**Fenwick Solar Farm
EN010143**

**Applicant's Response to Examining Authority's First Written
Questions (ExQ1)**

Document Reference: EN010152/APP/8.21

May 2025
Revision Number: 00

Scale
 0 25 50 100 200m
 Original Size (A1) 1:2500 @ A1 1:5000 @ A3

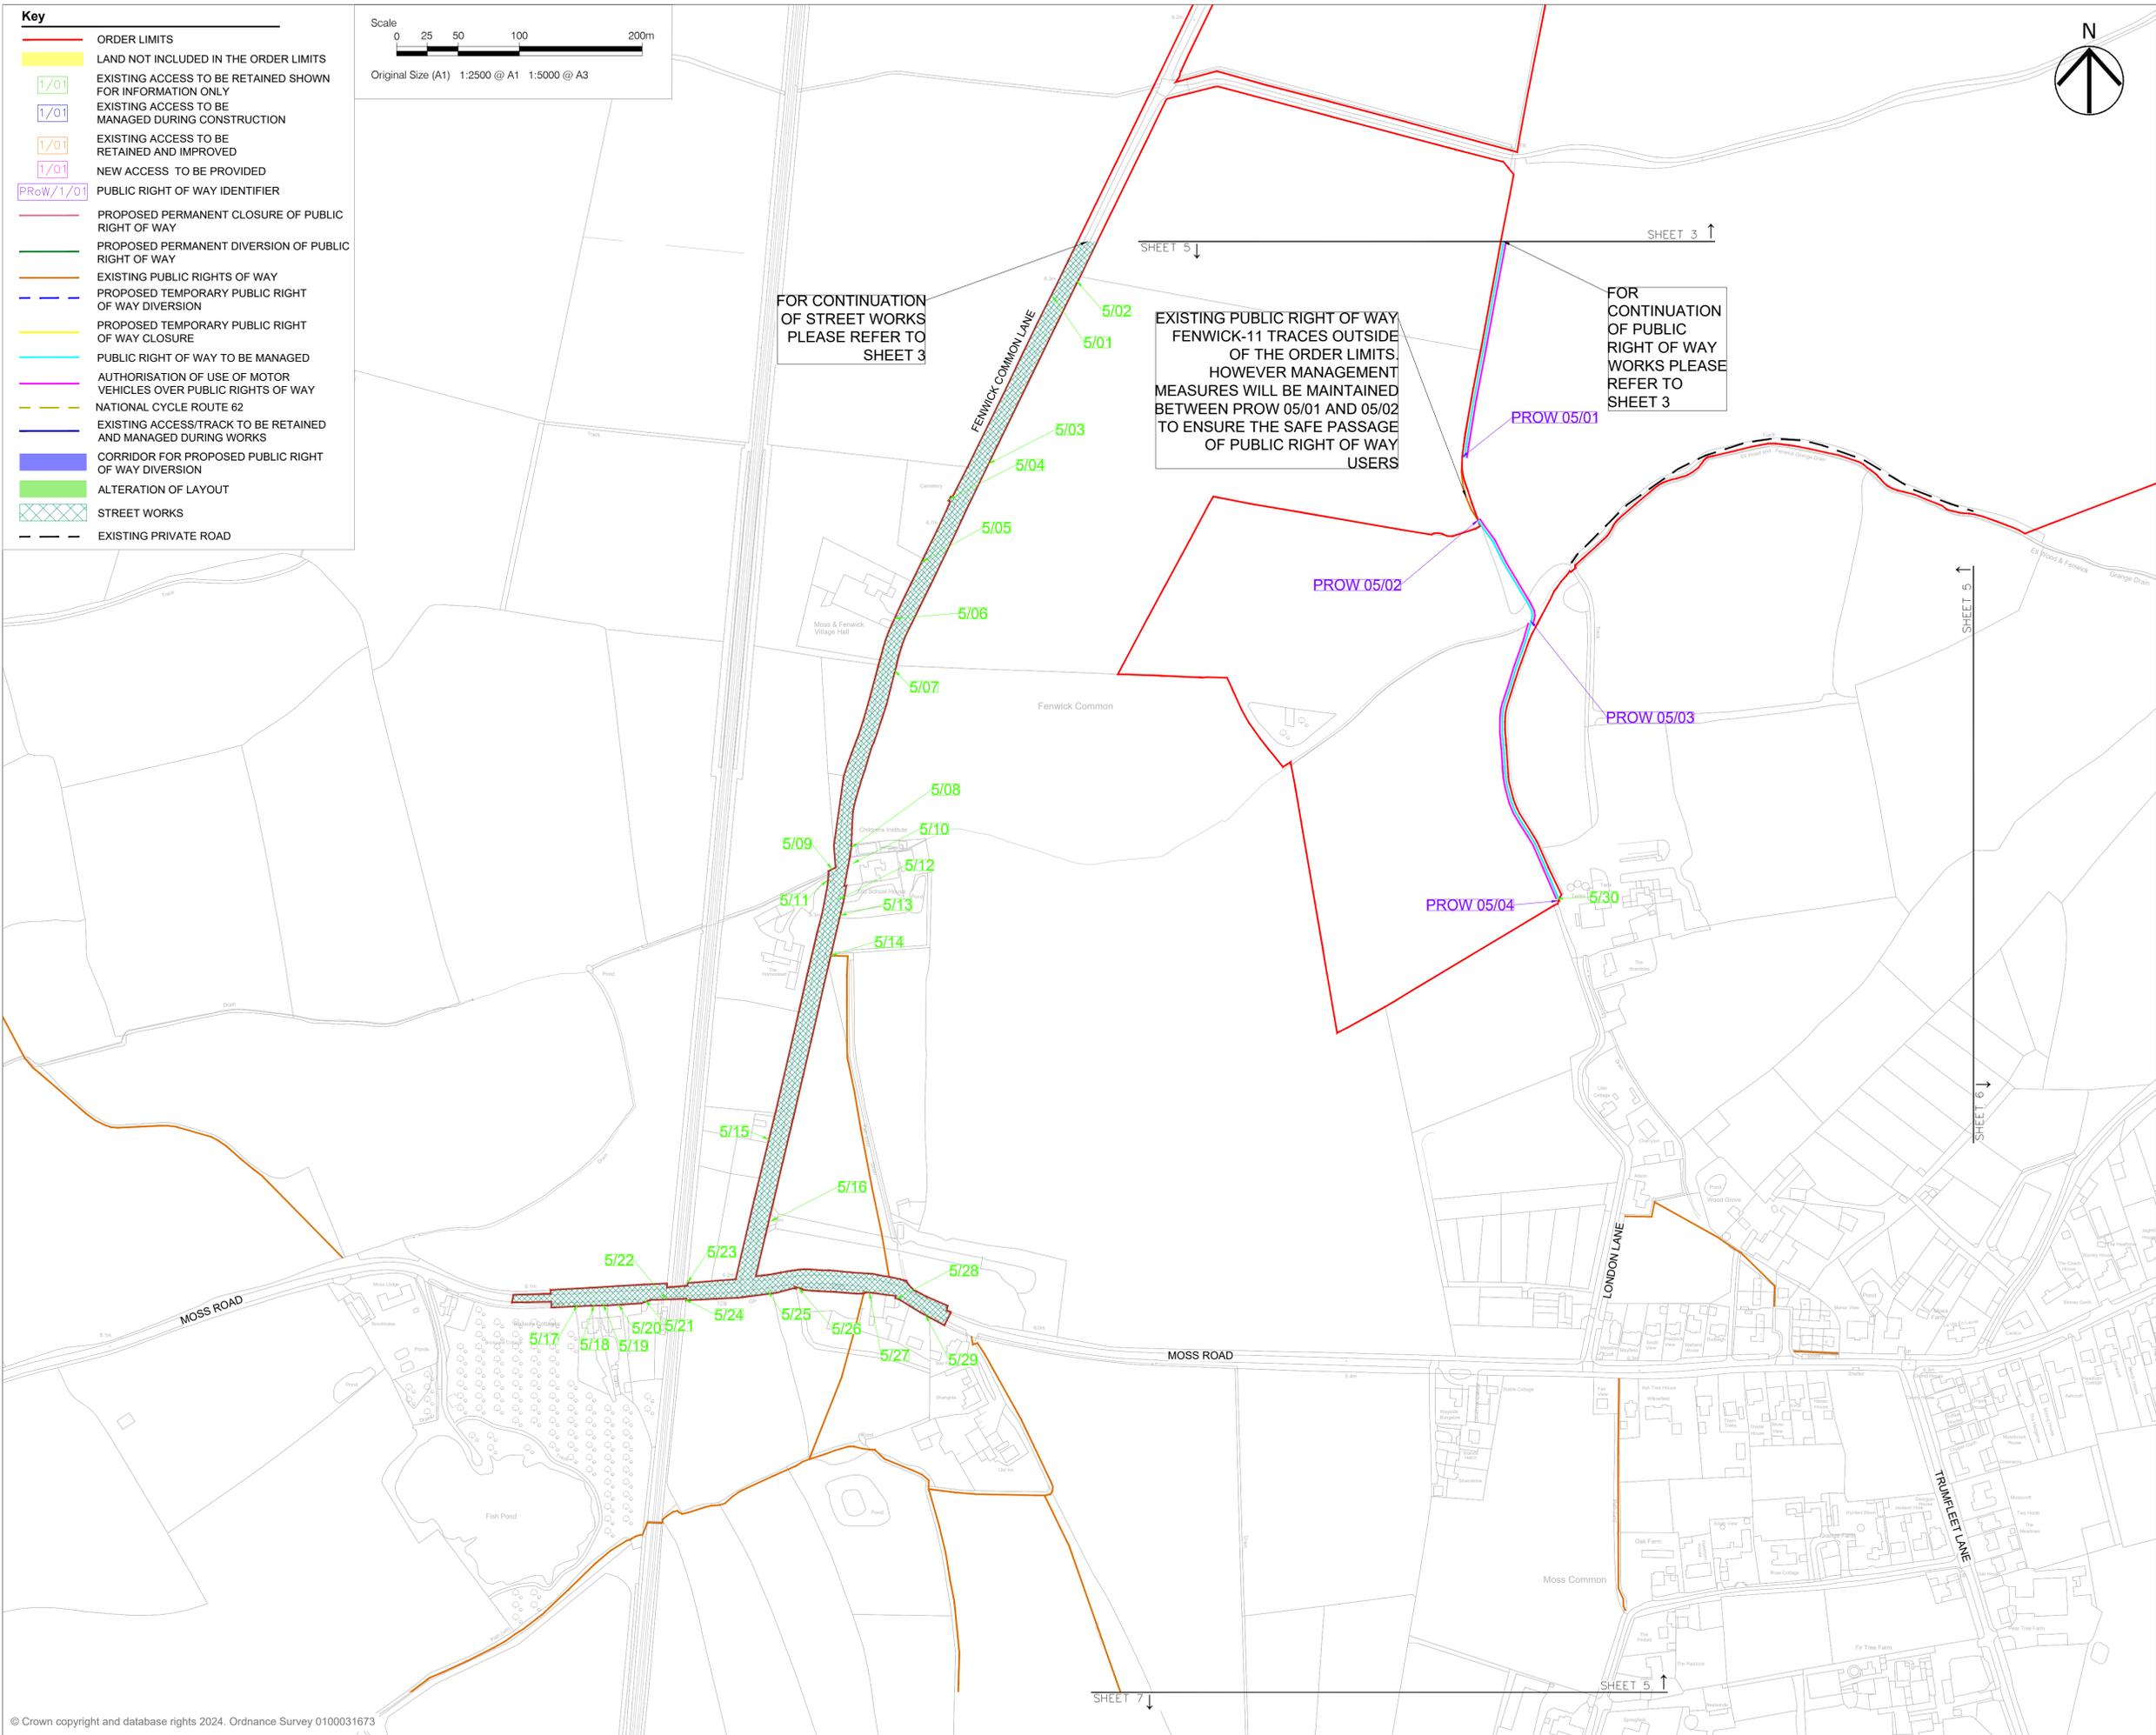
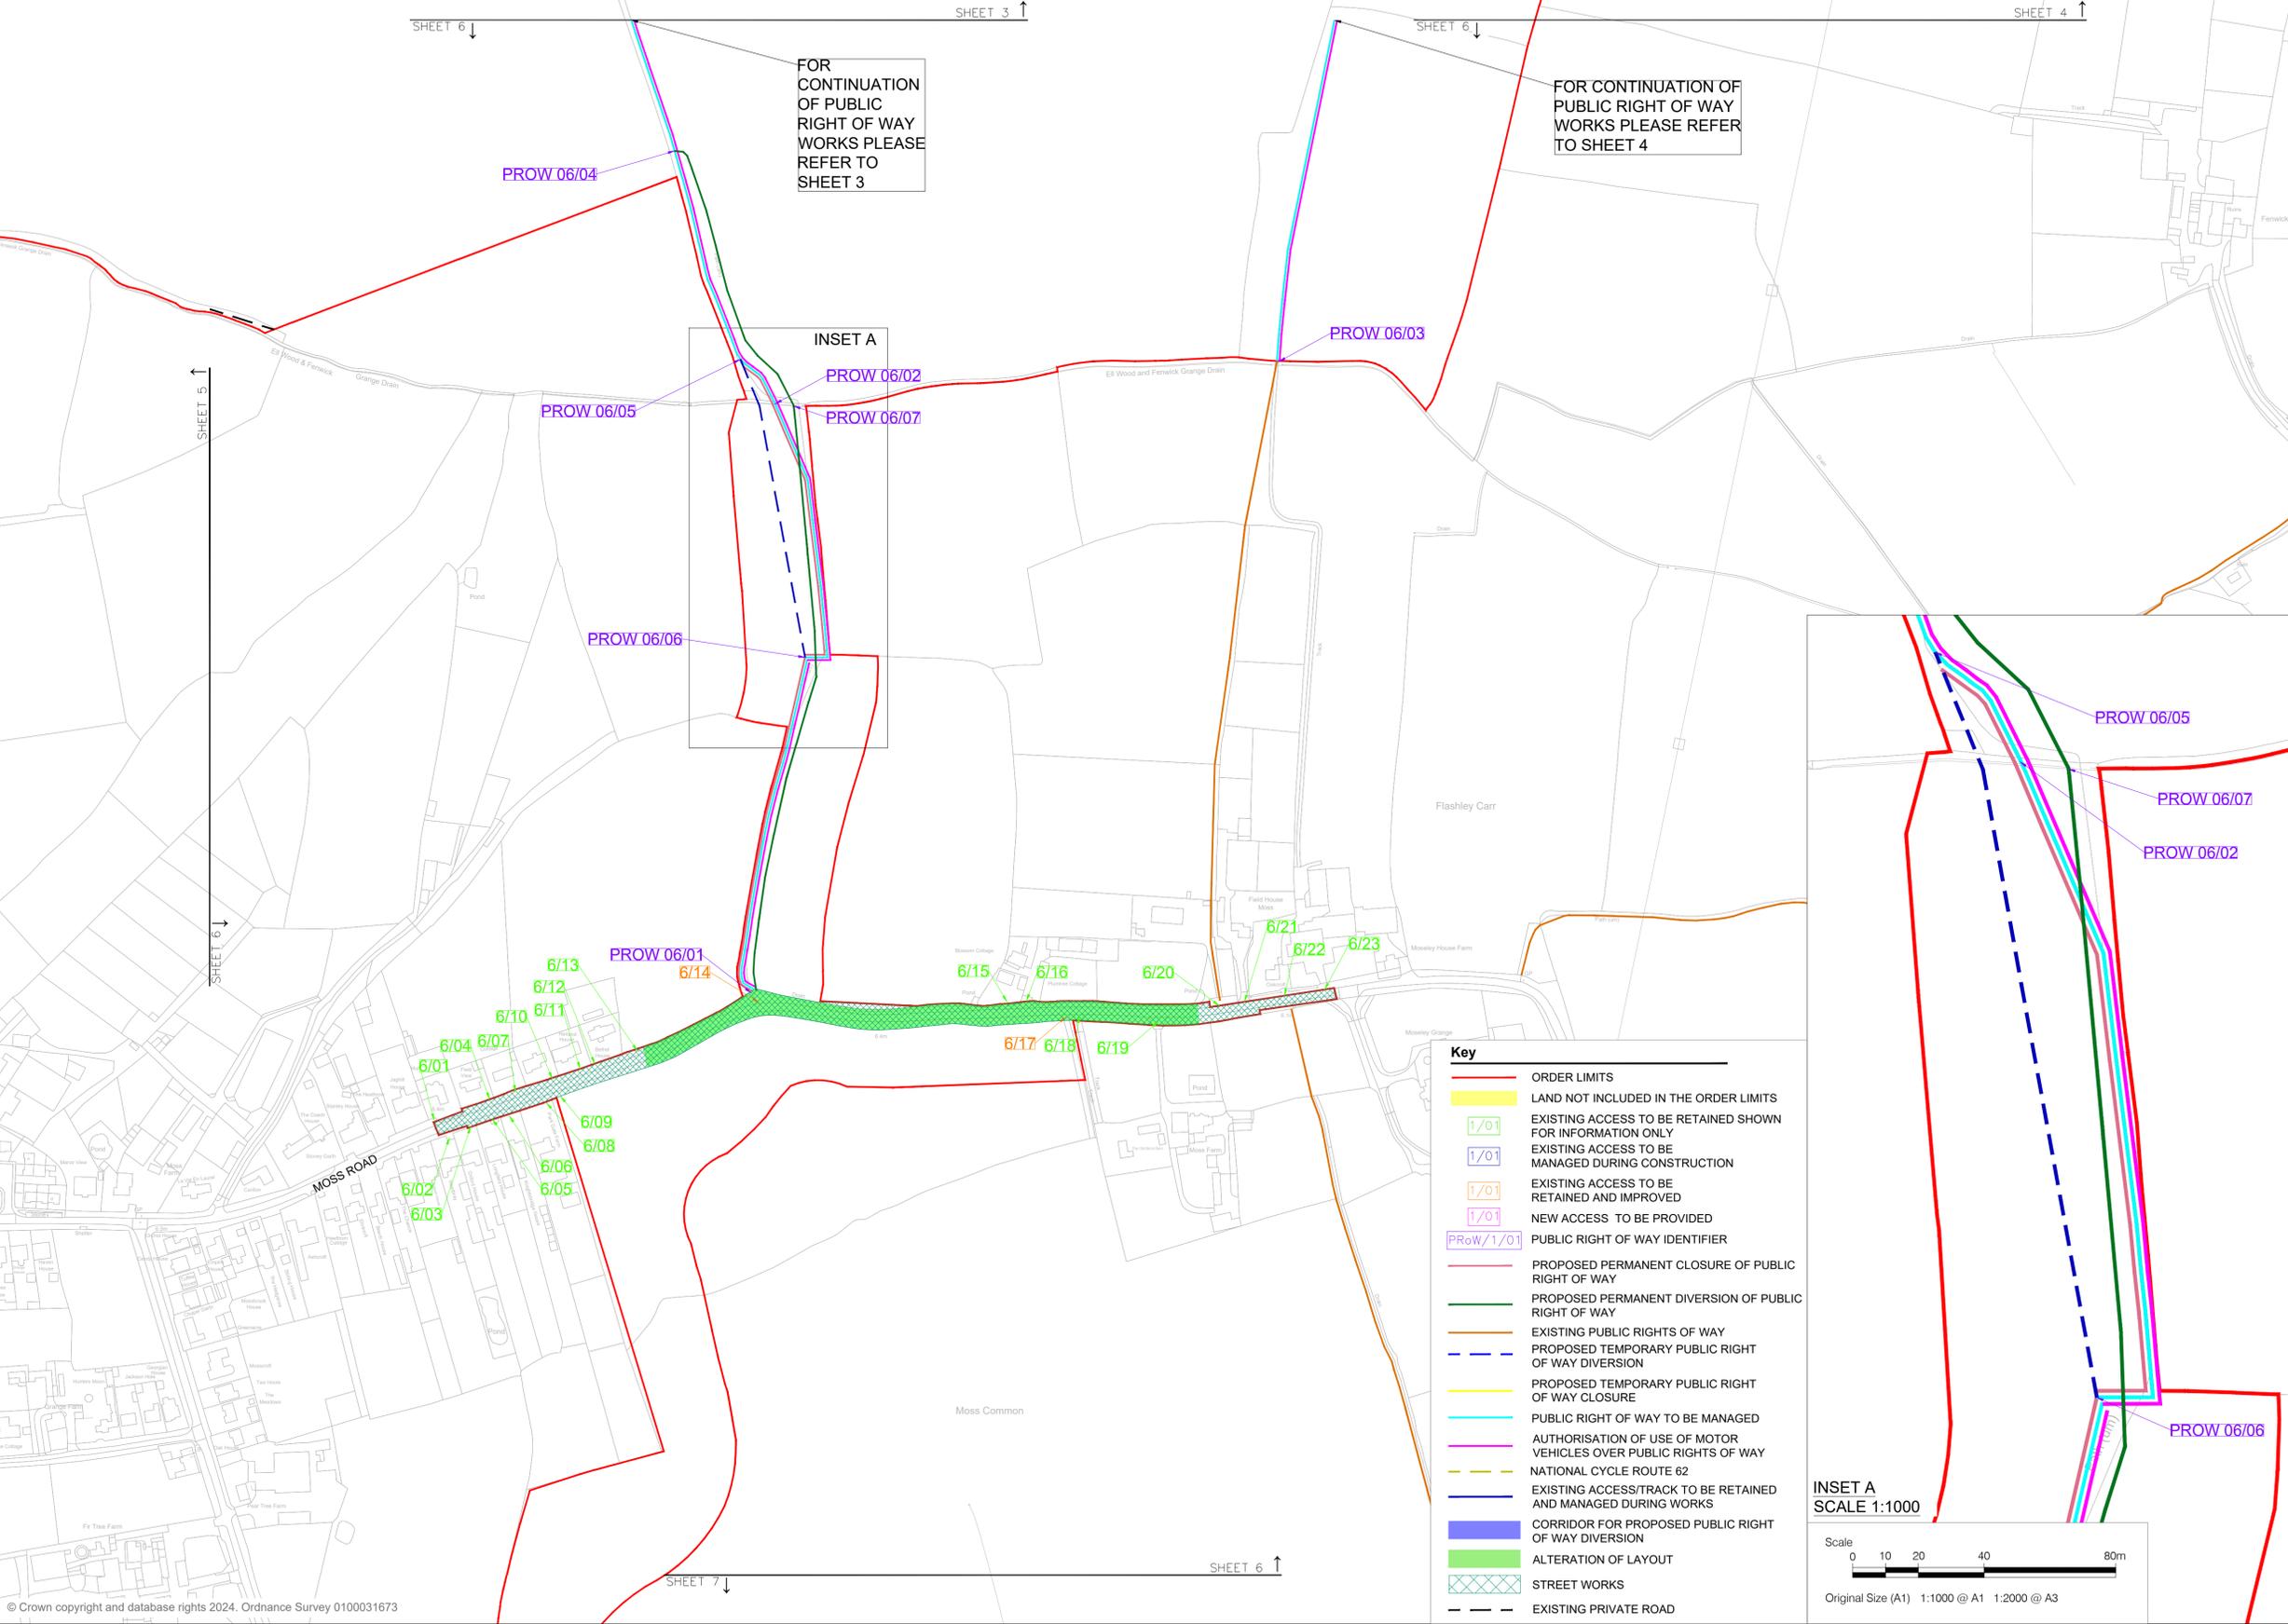
1.1.19	Applicant	<p>Schedule 4 (Streets subject to street works)</p> <p>The ExA notes the use of the words 'within proximity of' in this schedule are insufficiently precise. Please amend to a more precise form of words (eg. 'between points [x] and [y]') or provide a further justification for their use.</p>	<p>The Applicant considers the wording is sufficiently precise when reviewing the wording as against the Streets, Rights of Way and Access Plan (Revision 03) [EN010152/APP/2.3], as while the access points are used as a locational tool to help identify the area of streetworks within each sheet, the powers themselves are constrained instead to “the length shown in green patterned hatching”. The Applicant considers that to further define these</p>

ExQ1	Respondent	Question	Applicant's Response
			<p>extents using additional markers confirming the various edges of these streetworks would make this Plan overly cluttered and less applicable for the undertaker and local streets authorities.</p> <p>It is further noted that this approach to identifying streetworks (ie to rely on the areas as shaded in highlight or hatching) has been adopted and considered sufficiently precise on other recently made solar DCOs, including the Gate Burton Energy Park Order 2024, the Mallard Pass Solar Farm Order 2024 and the East Yorkshire Solar Farm Order 2025.</p>
